WISWELL PARISH COUNCIL

Planning Application No: 3/2011/0850
Alterations to windows and porch (re-submission)
36 Pendleton Road, Wiswell, Clitheroe, BB7 9DD

Client L TATTERSALL	Scale 1:50 @ A1
Project WOODCROFT COTTAGE PENDLETON ROAD WISWELL	Date JUL 2011
Description PROPOSED ELEVATIONS	By SEV
	Checked TH.
	No. 2816/202

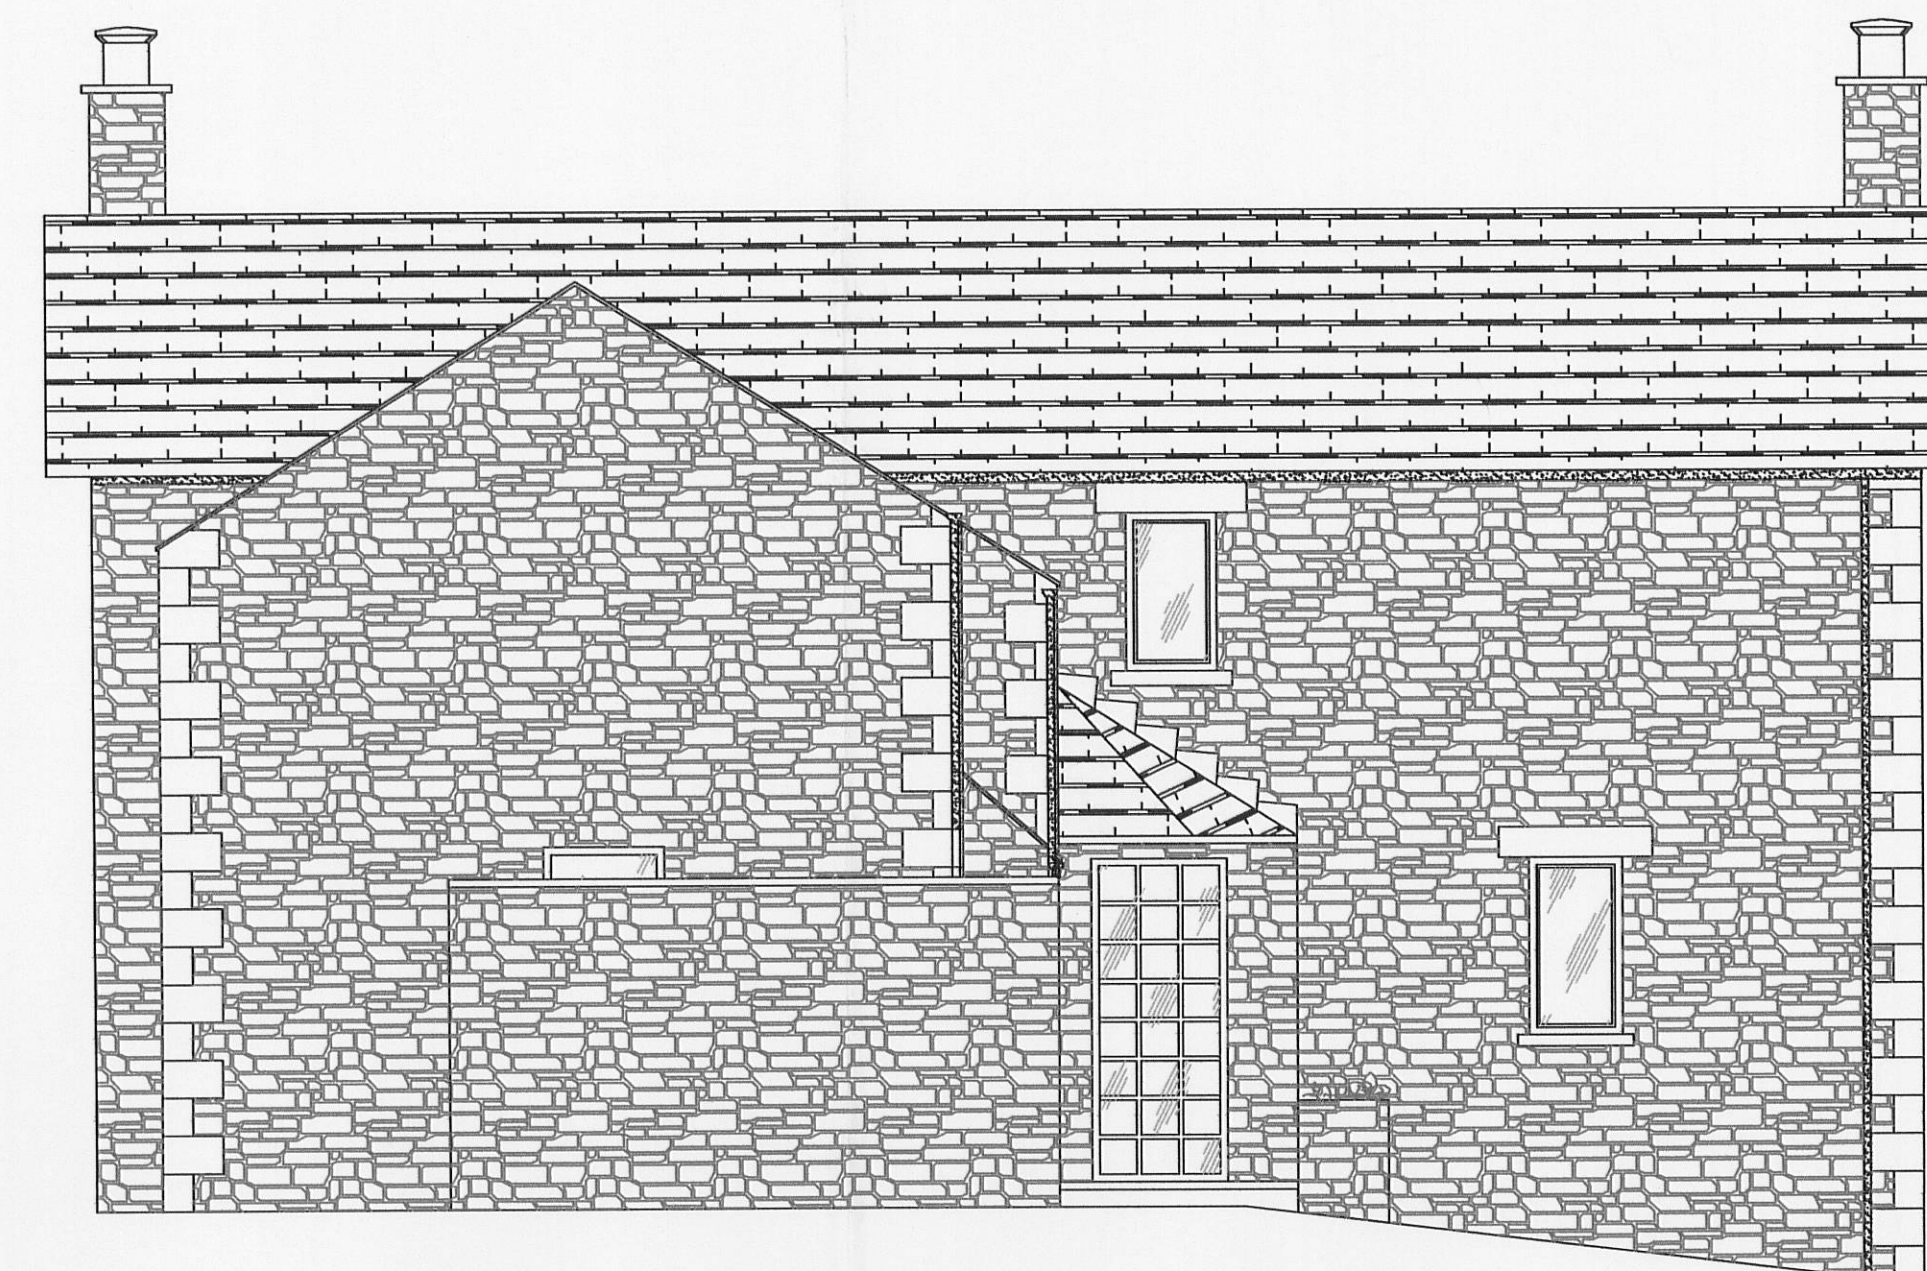
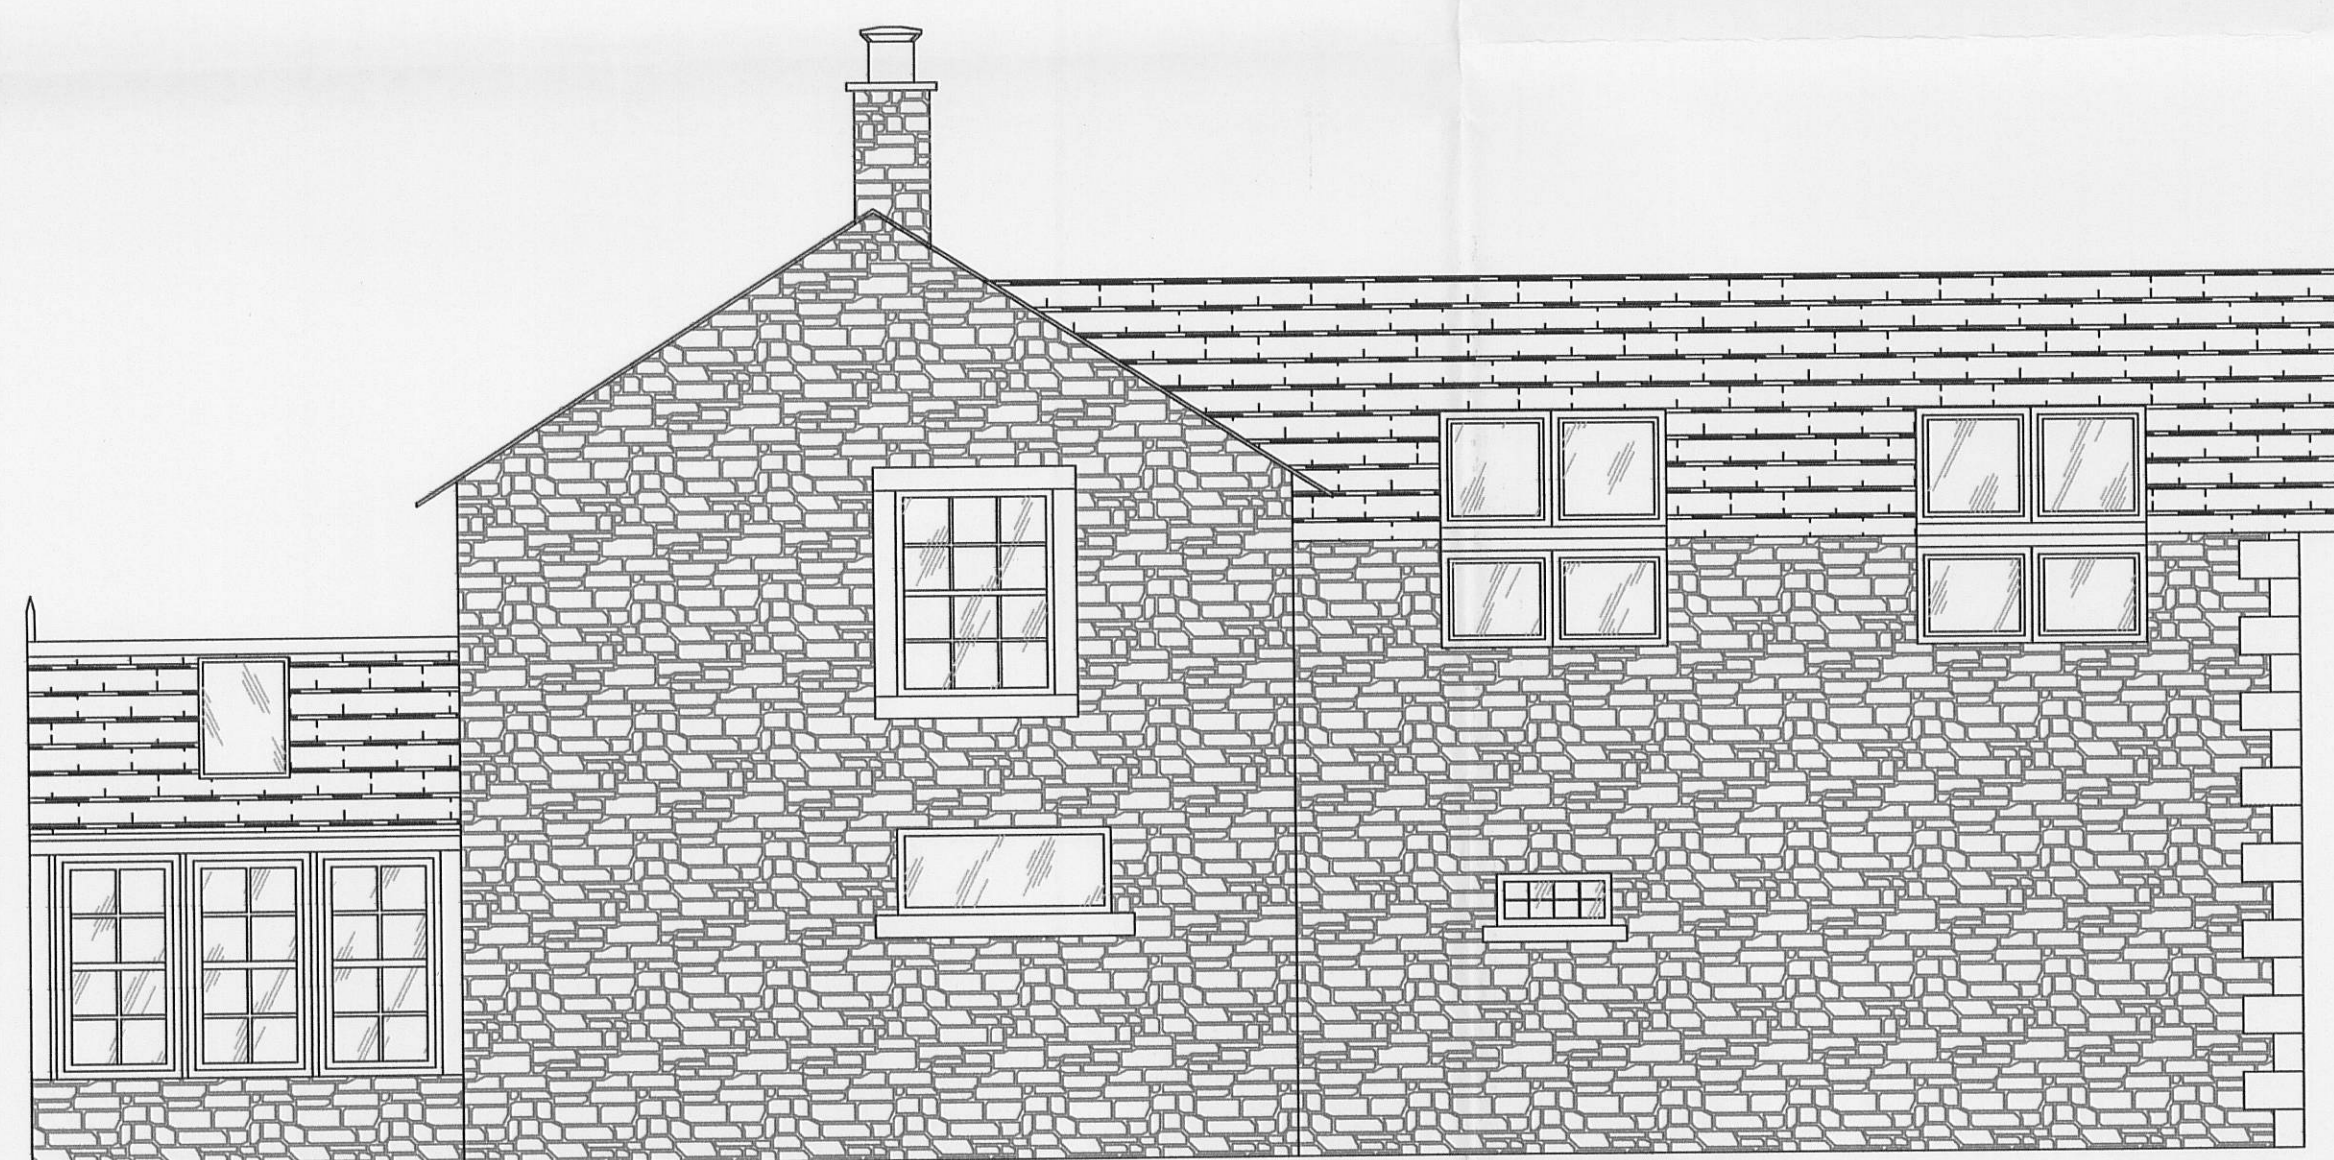
The above application has now been considered by members of the Parish Council. The Councillors are concerned that the overhanging roof is not traditional or in keeping with other cottages in the village. Also, on the side elevation facing the road, the Councillors would ask that the existing windows be retained.
